Proposed S4.55 (1A) Modification to SSD-35370706 Uniting Charlestown Development DA Mod 2

*Architectural Comparison –
Stamped Approved Plan & DA MOD 2 Plans*

DRAWING TITLE
FLOOR PLAN - LEVEL 09

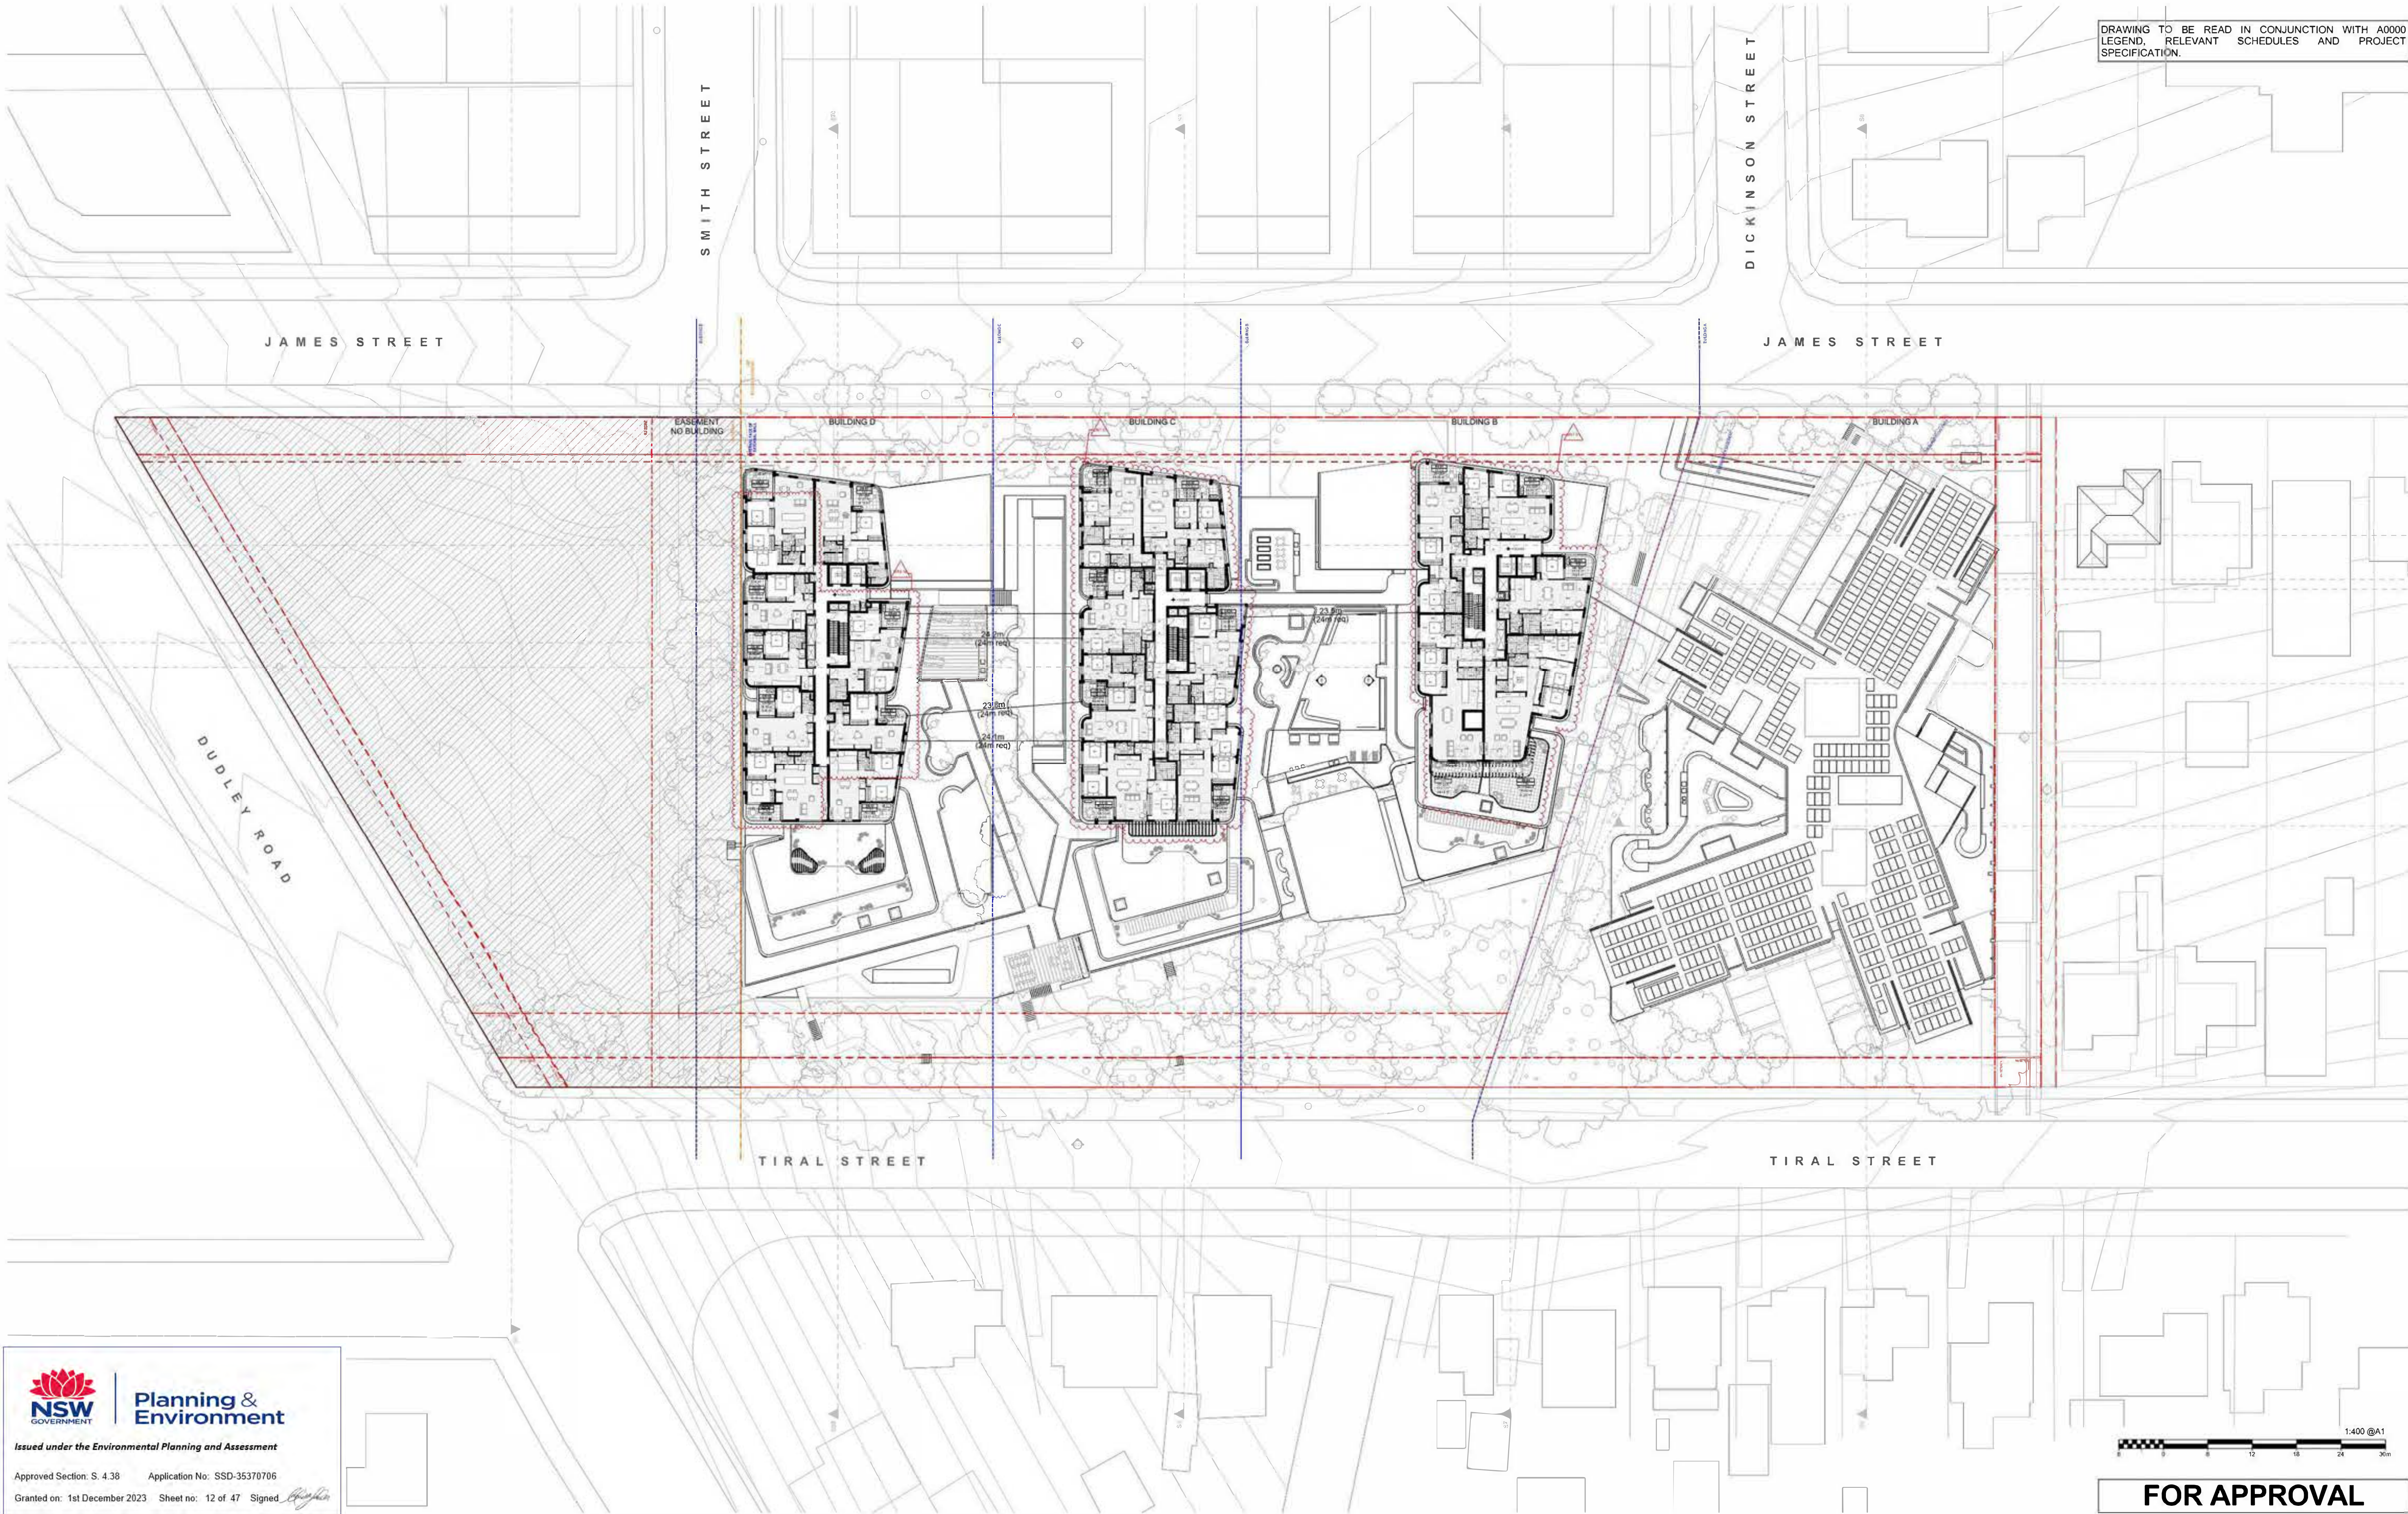
- * 2 Northern units have gain area. B9.01 connects behind the Fire egress - gain area
- * Western unit deleted - gained balcony area
- * 2nd Lift area has reduced gain area
- * Main 2 lifts shift where the gain is greater than the loss
- * Internal layout adjusted to reflect ongoing stakeholder consultation and provide better amenity for occupants.
- * Change in extent of terrace and awning roof materiality.
- * Change in façade layout and finishes
- * Change in RL from RL123,650 to RL123,940
- * Roof converted to private residential terrace to increase residential amenity

DRAWING TITLE
FLOOR PLAN - LEVEL 10

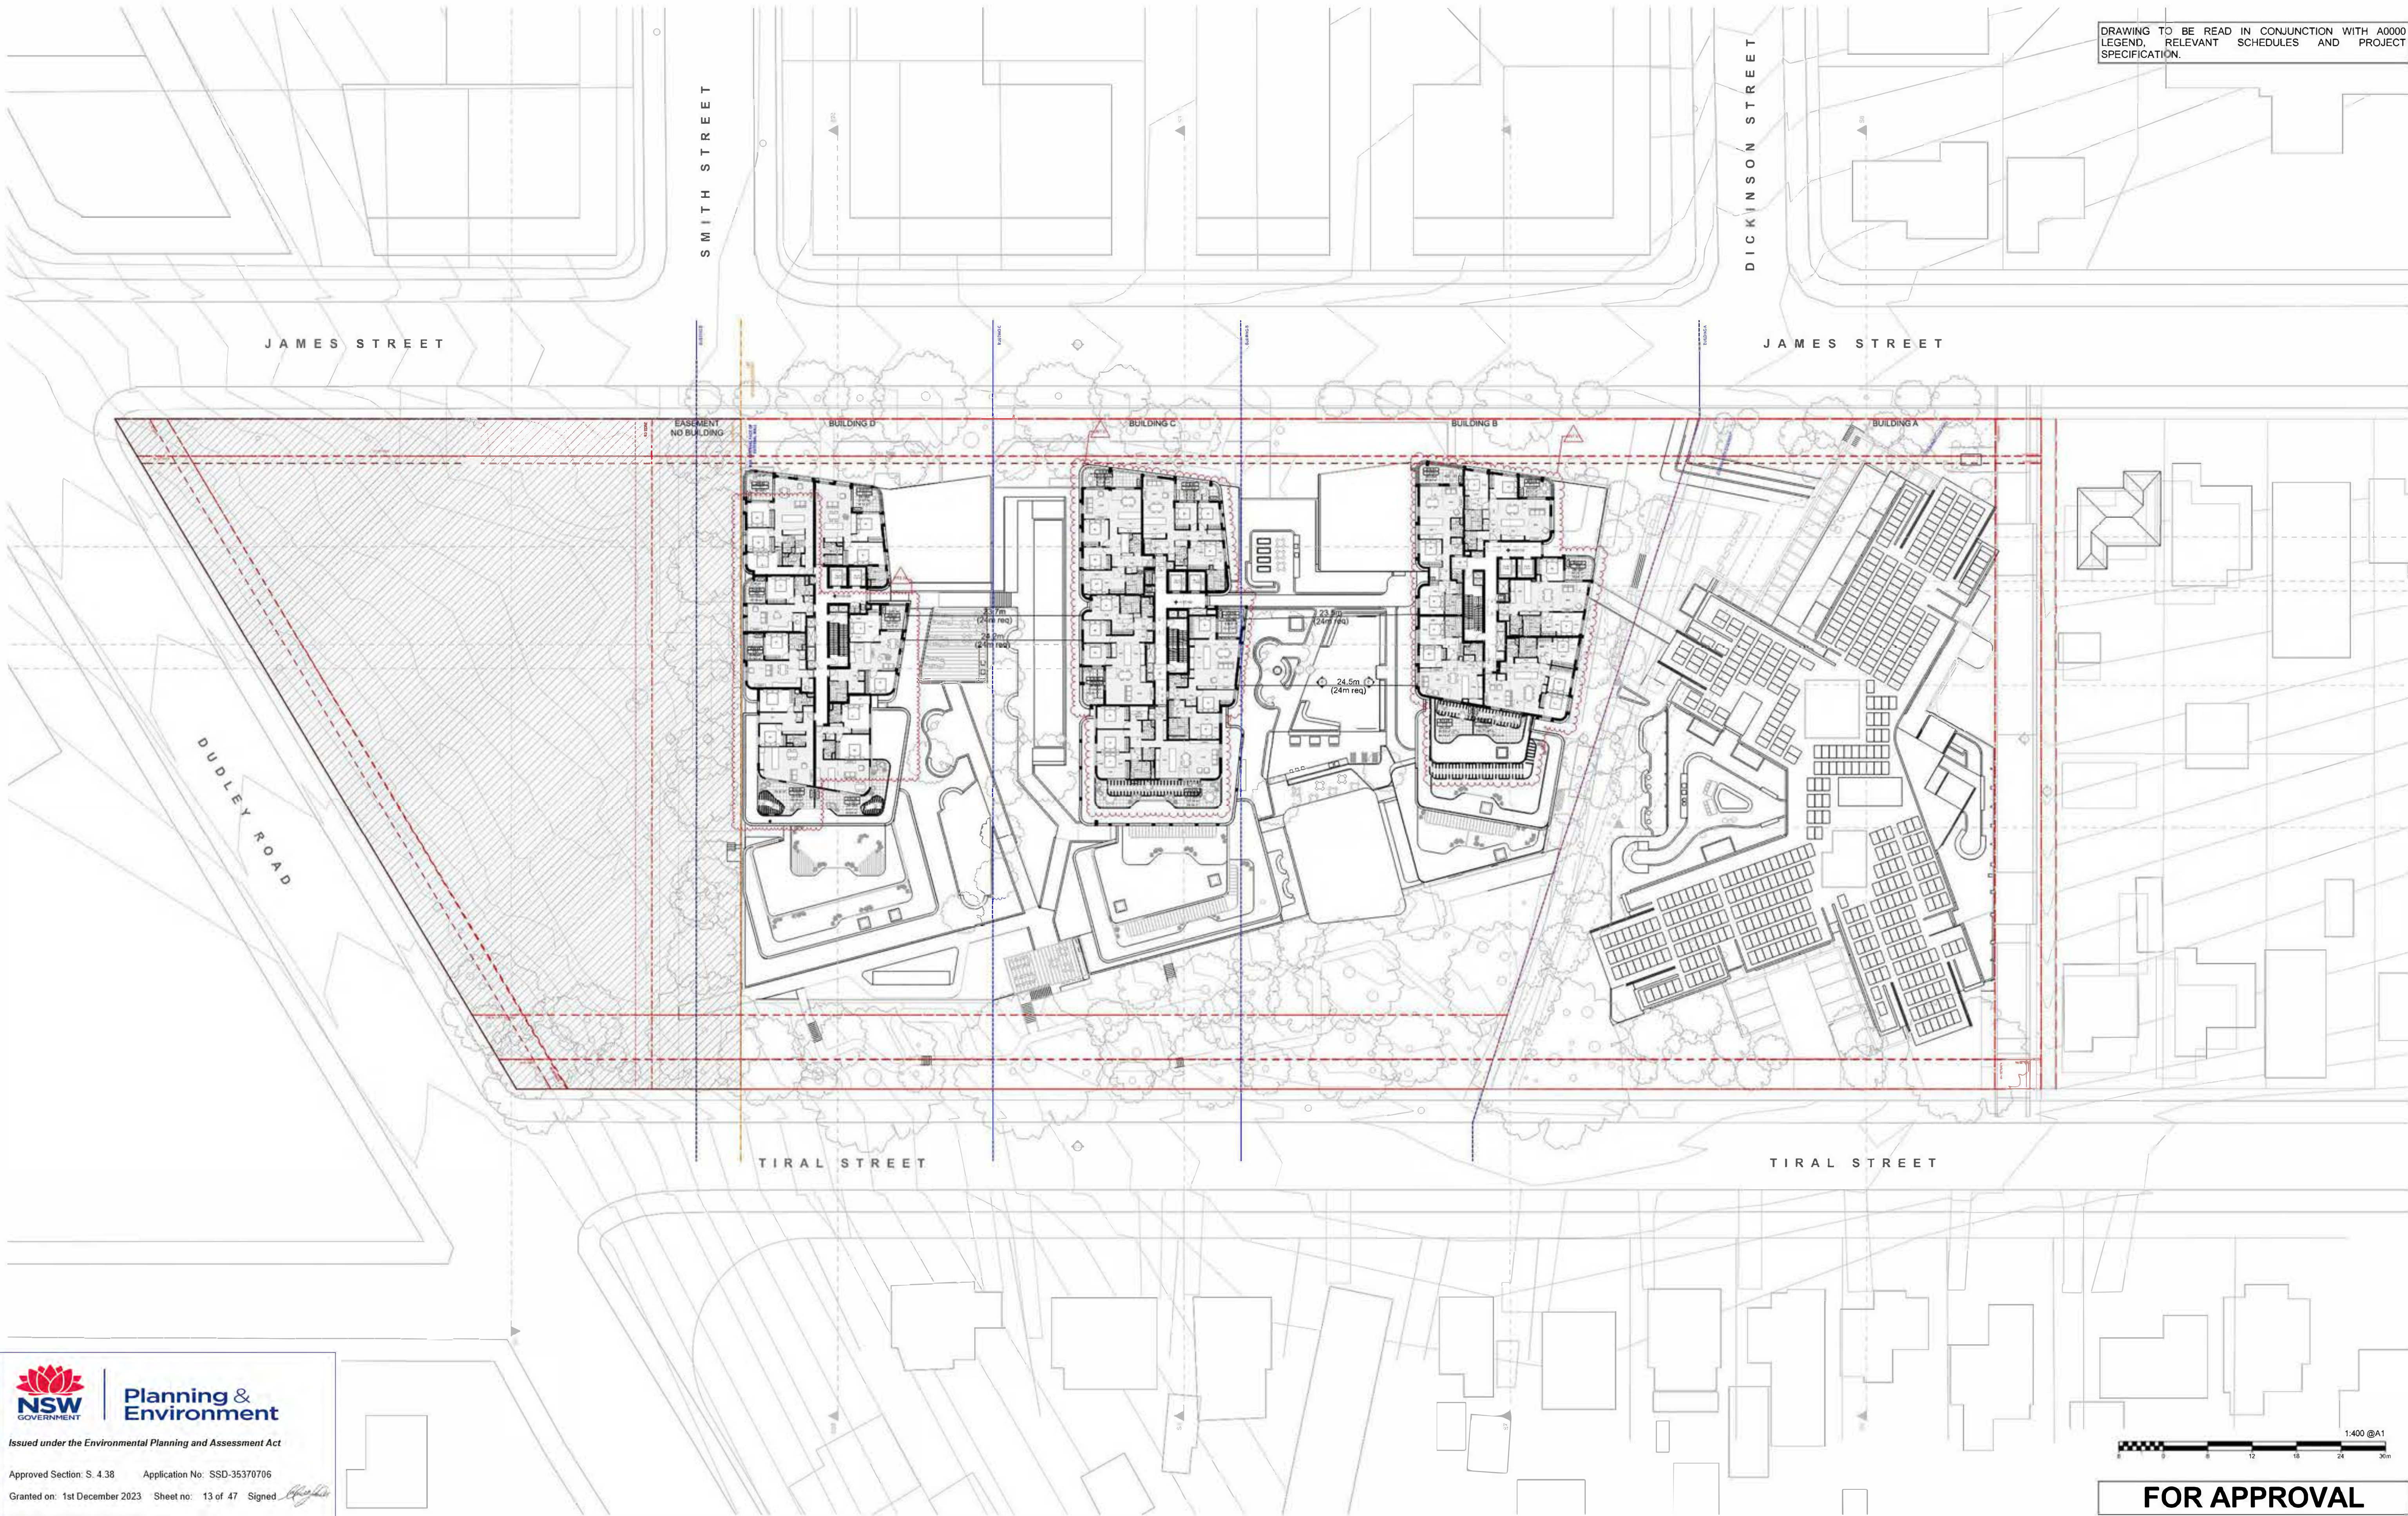
- * Main 2 lifts shift where the gain is greater than the loss
- * Internal layout adjusted to reflect ongoing stakeholder consultation and provide better amenity for occupants.
- * Change in extent of terrace and awning roof materiality.
- * Change in façade layout and finishes Change in RL from RL127,150 to RL127,290
- * Roof converted to private residential terrace to increase residential amenity
